Planning and Urban Development Department

Date: May 23rd, 2014

Re: **May 27th, 2014 Planning Board Workshop**
 Level III Site Plan and Subdivision Review
 5-unit multi-family building
 97 Cumberland Avenue
 Peter Dugas, Applicant

Preliminary Site Plan

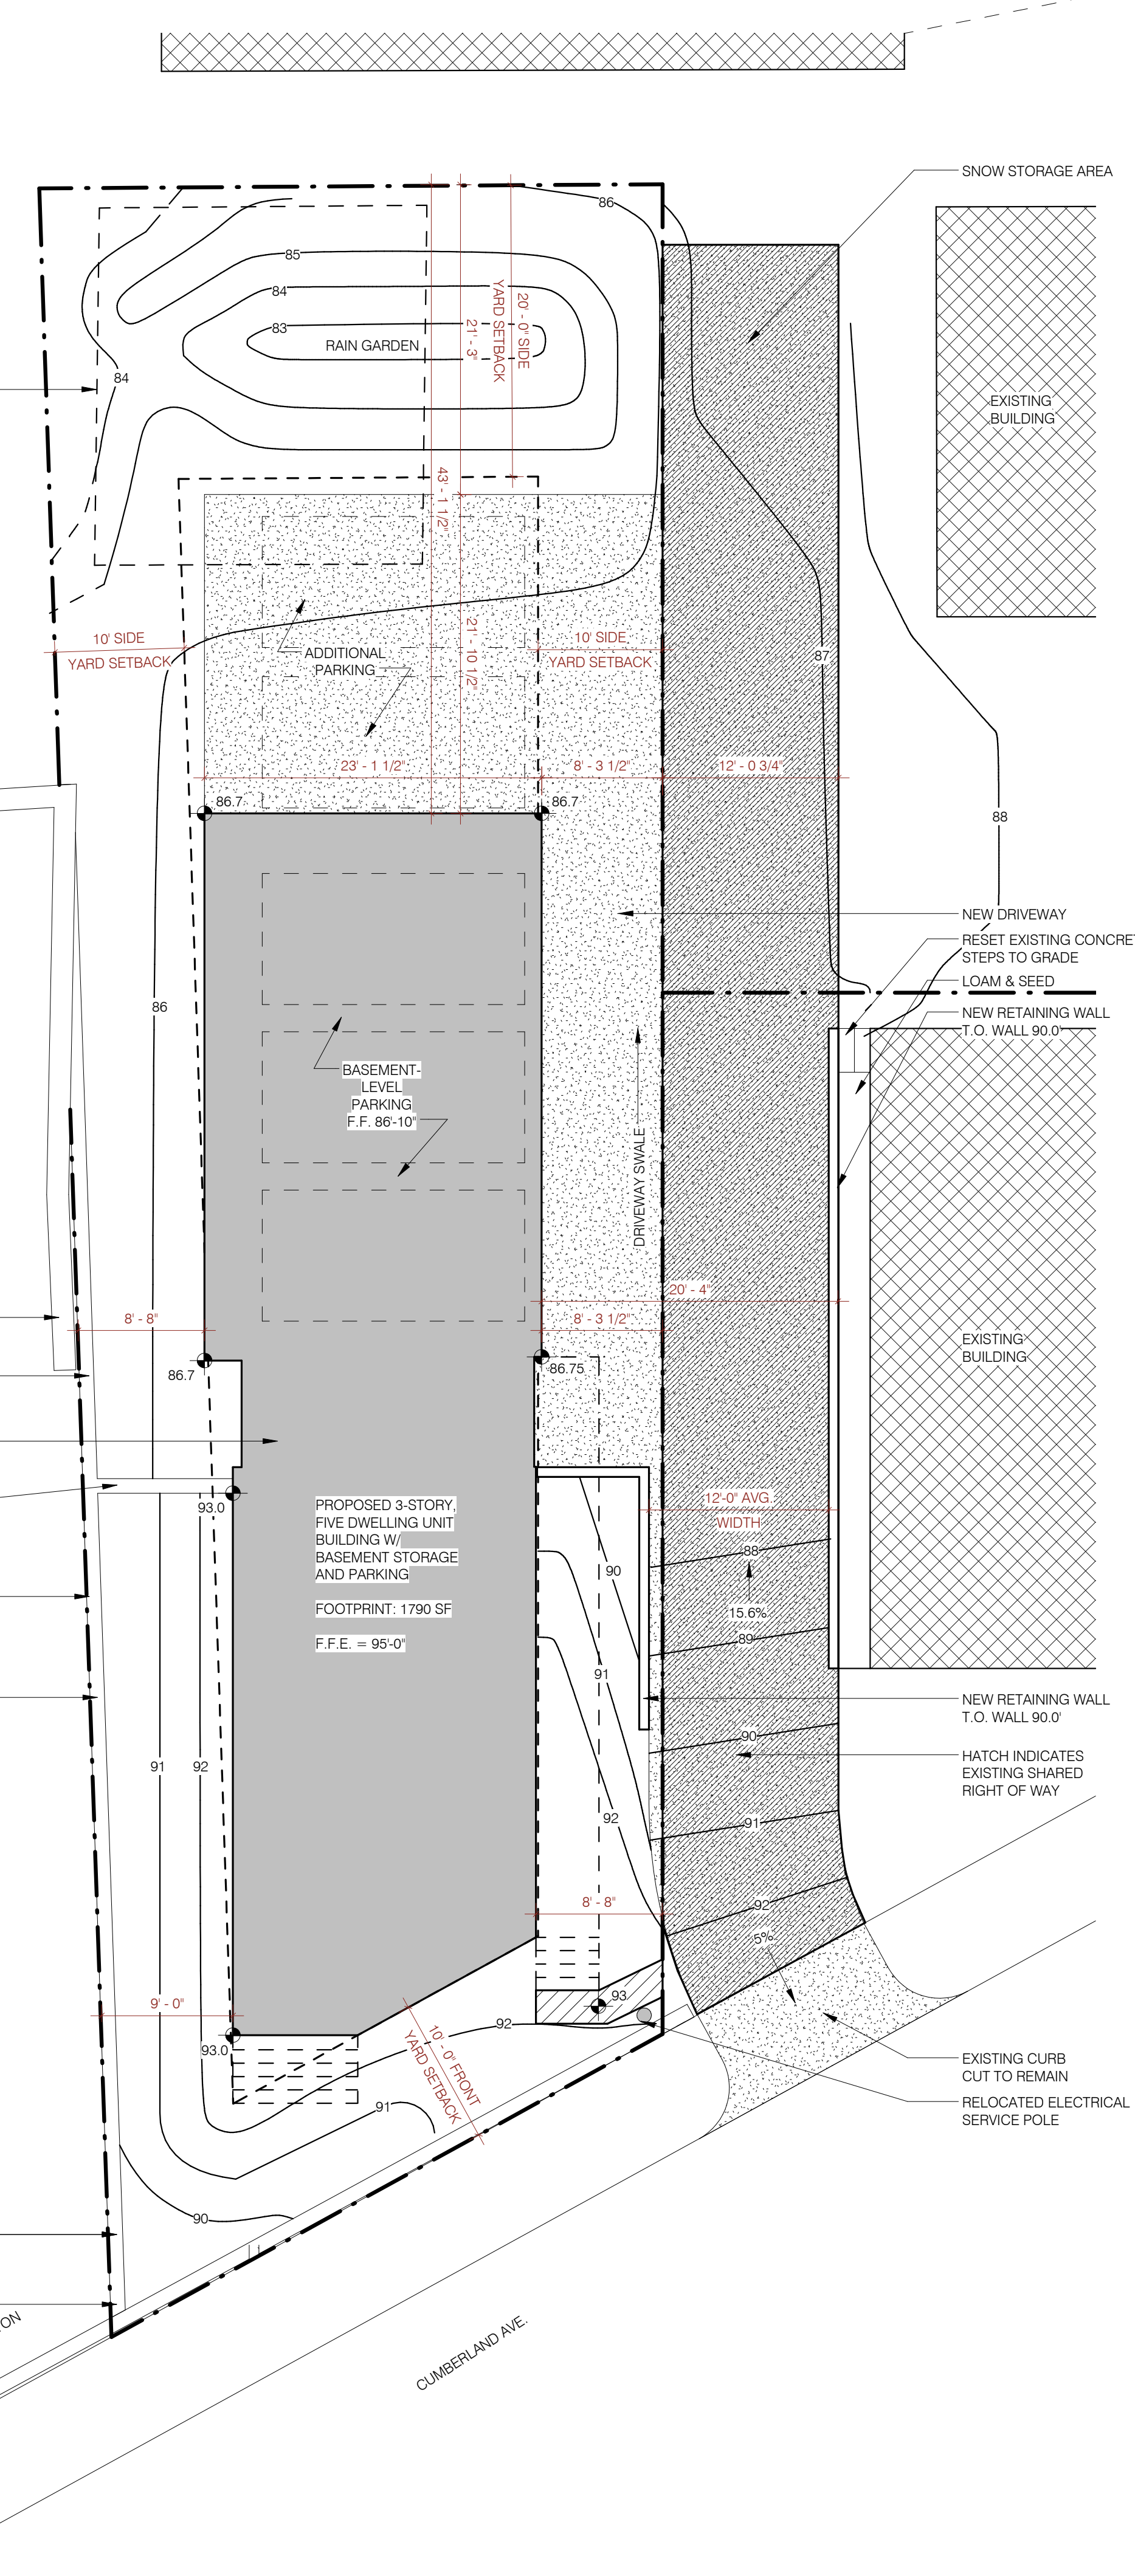
I have reviewed this project for a new 5 unit residential 3-story structure. My major concern after this review is the required 10' side setback for the building. Both sides are not meeting the required minimum 10' setback. I am uncertain why the applicant is showing that there is less than the required 10' side yard setback when the document acknowledges the 10' required. All other R-6 dimensional requirements are being met.

The proposed access utilizes the existing driveway that serves the three lots. Its effective width is proposed to be narrowed to 12 feet (see Plan P2) which is considered acceptable in terms of a driveway but may preclude parking in the driveway by users who have rights to that area.

The Site Plan shows snow storage within the abutters lot (rear part of 93 Cumberland Avenue) and as noted by Tom Errico ([Attachment 2](#)) this may also interfere with other users of the Right of Way drive access. The applicant is requested to confirm that he has rights to place snow at this location.

It is understood that the discrepancy is not great, but the applicant will need to revise the proposals to fully meet the zoning requirements.

A3.1

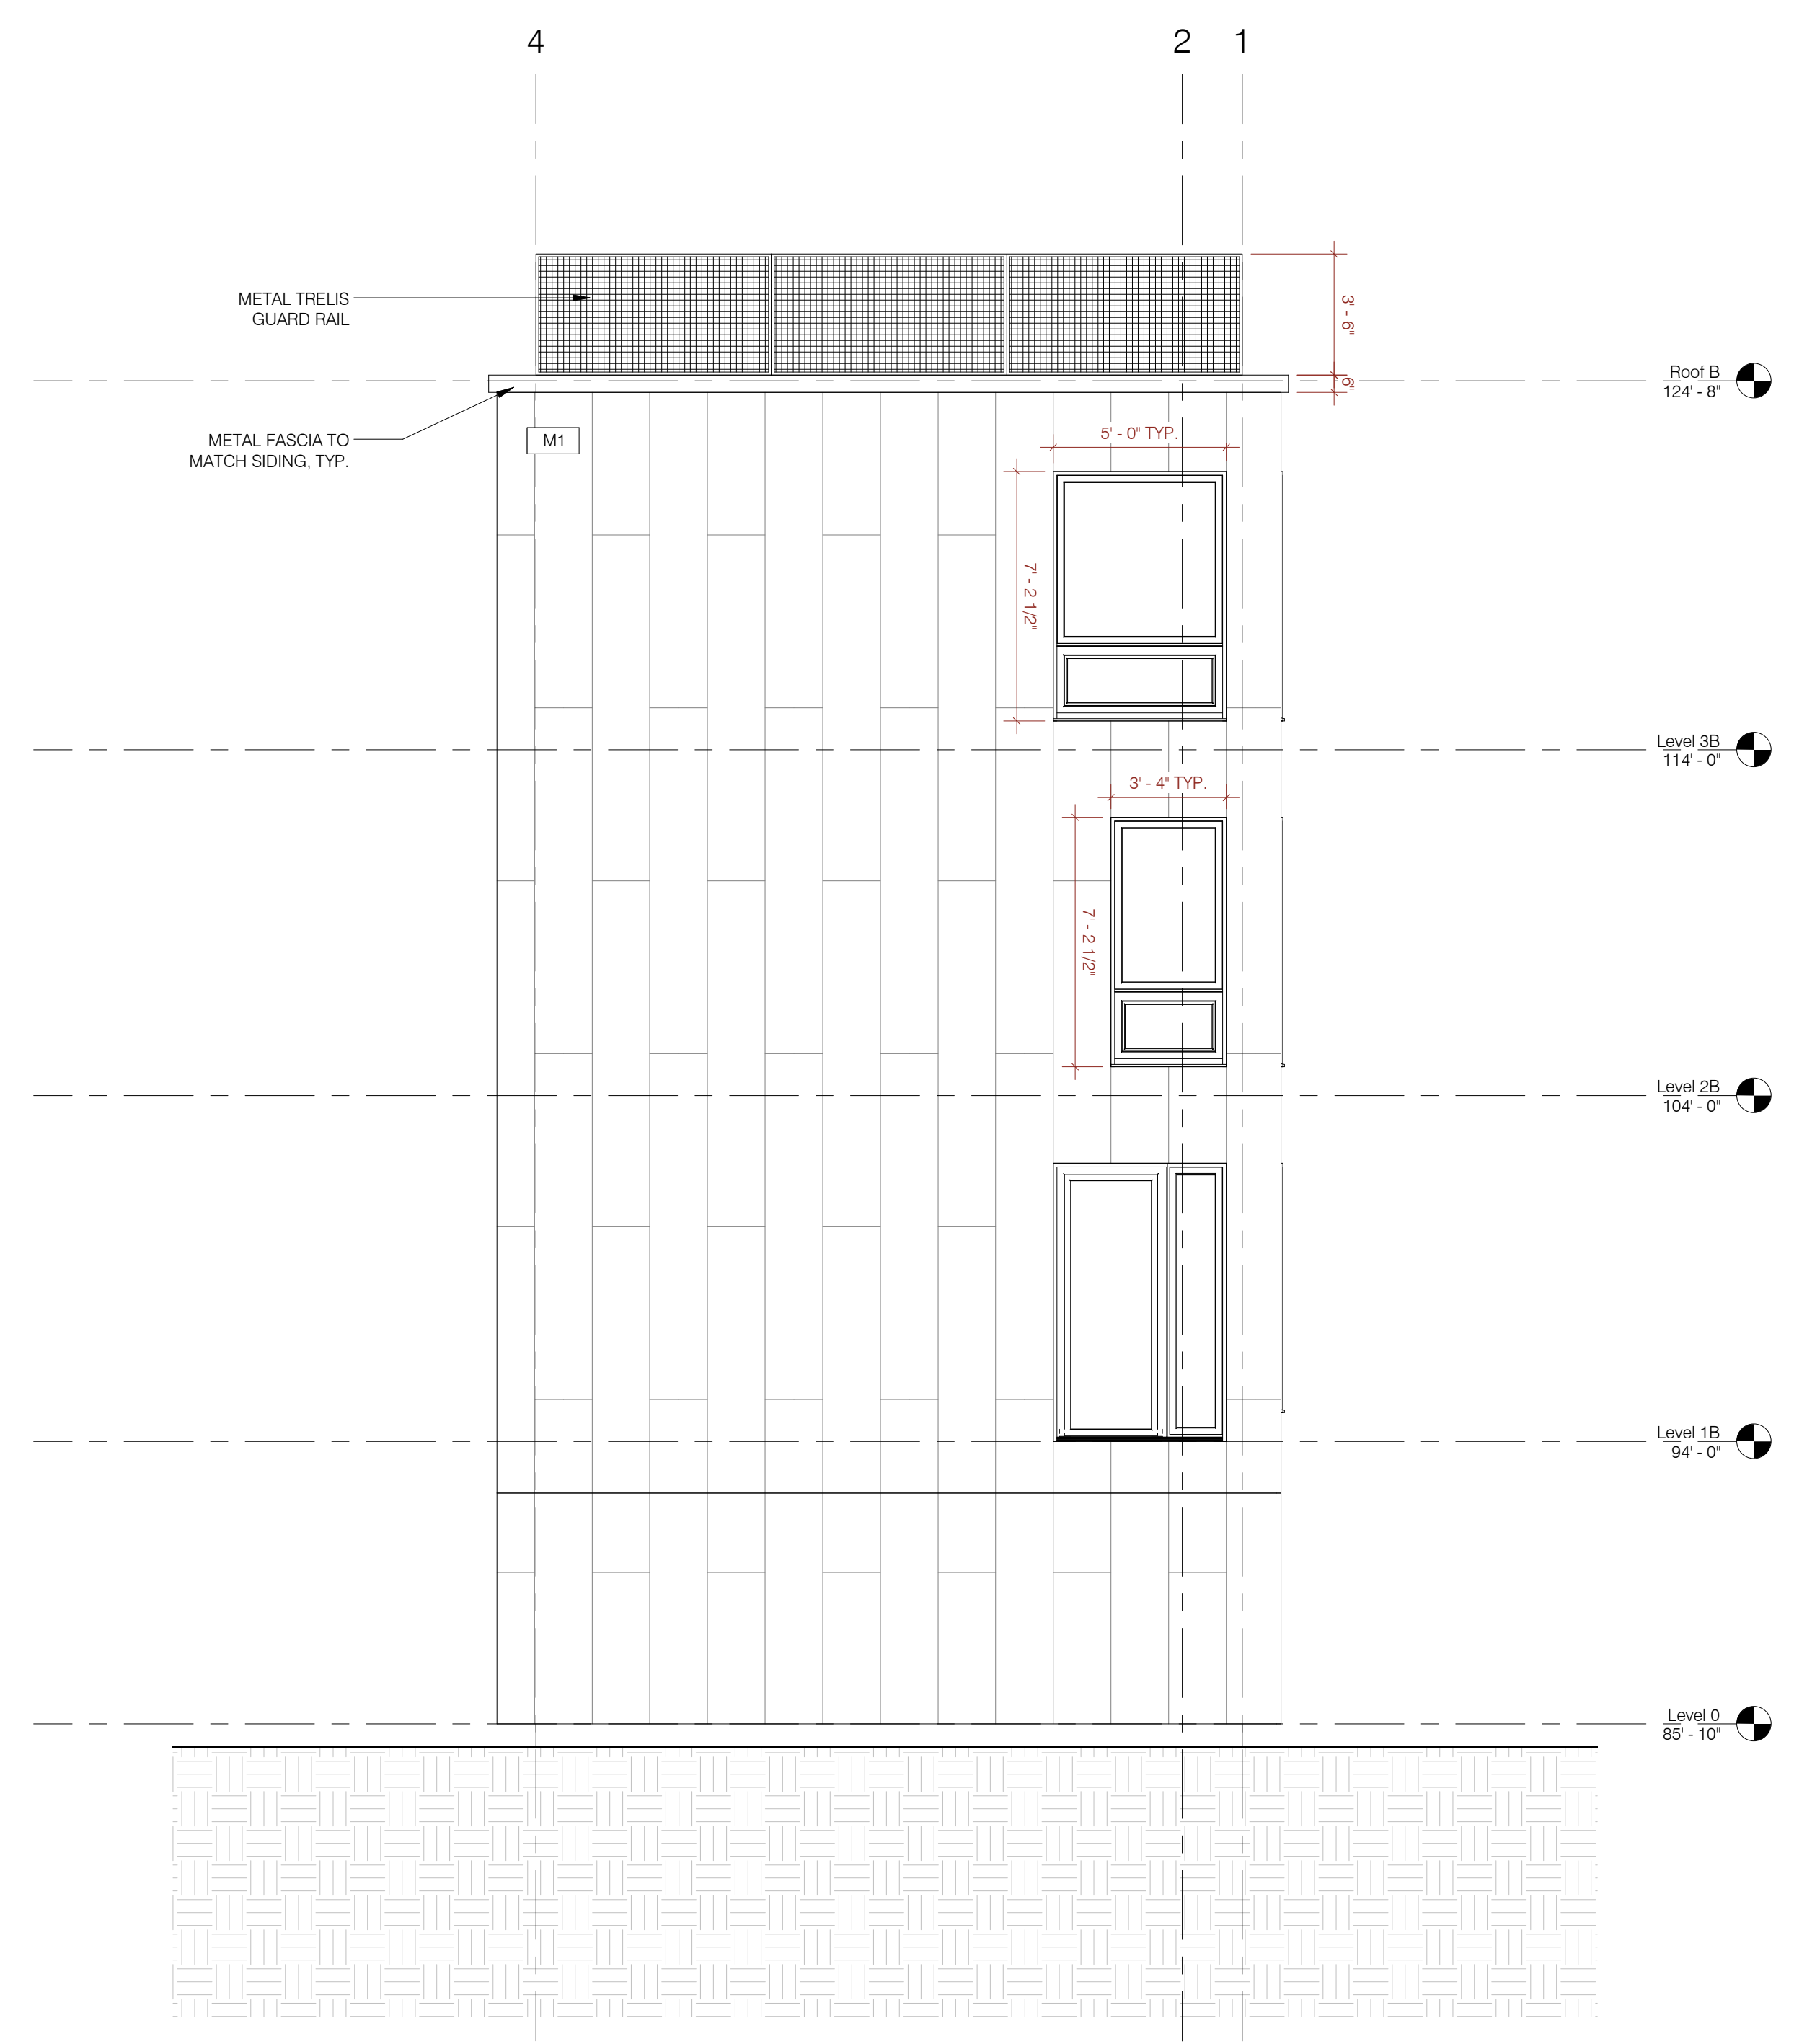
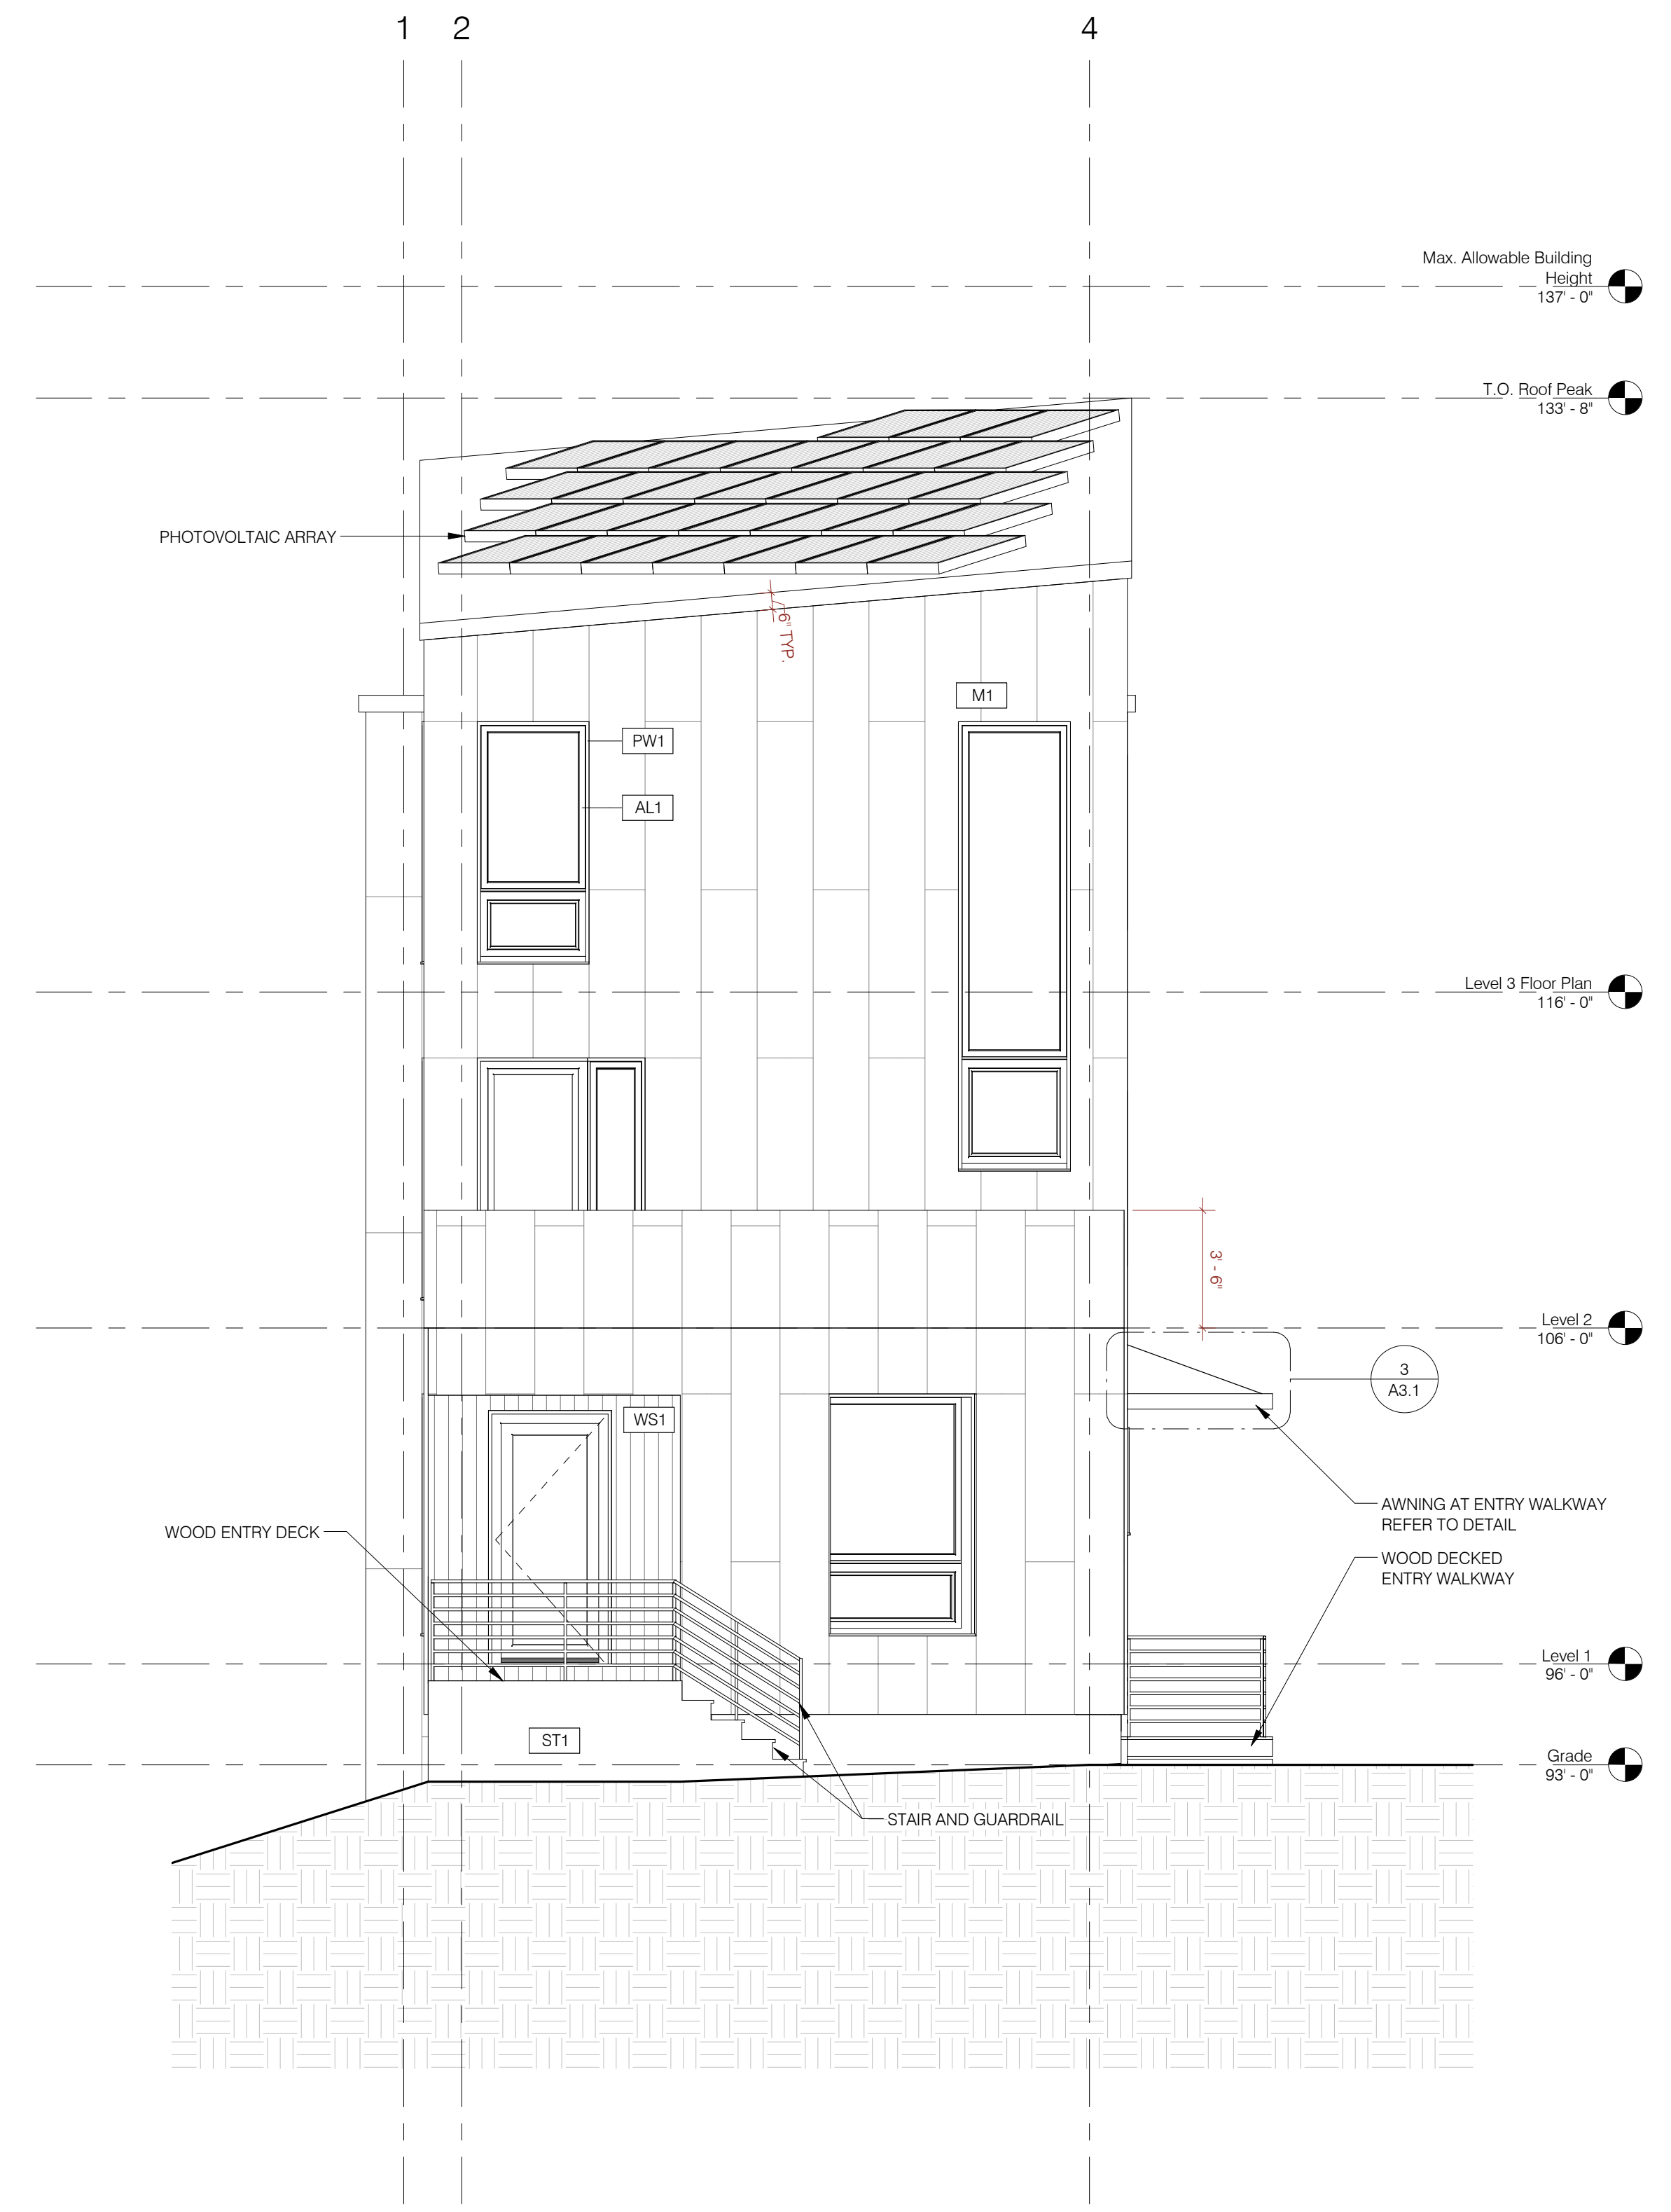
The proposals, including floor plans and elevations, are shown in the Plan set. The proposed building has 3 levels in the front part and 4 levels in the rear section, with parking on the lowest level. The overall building height is approximately 40 feet as shown in the elevations ([Plans P10](#)).
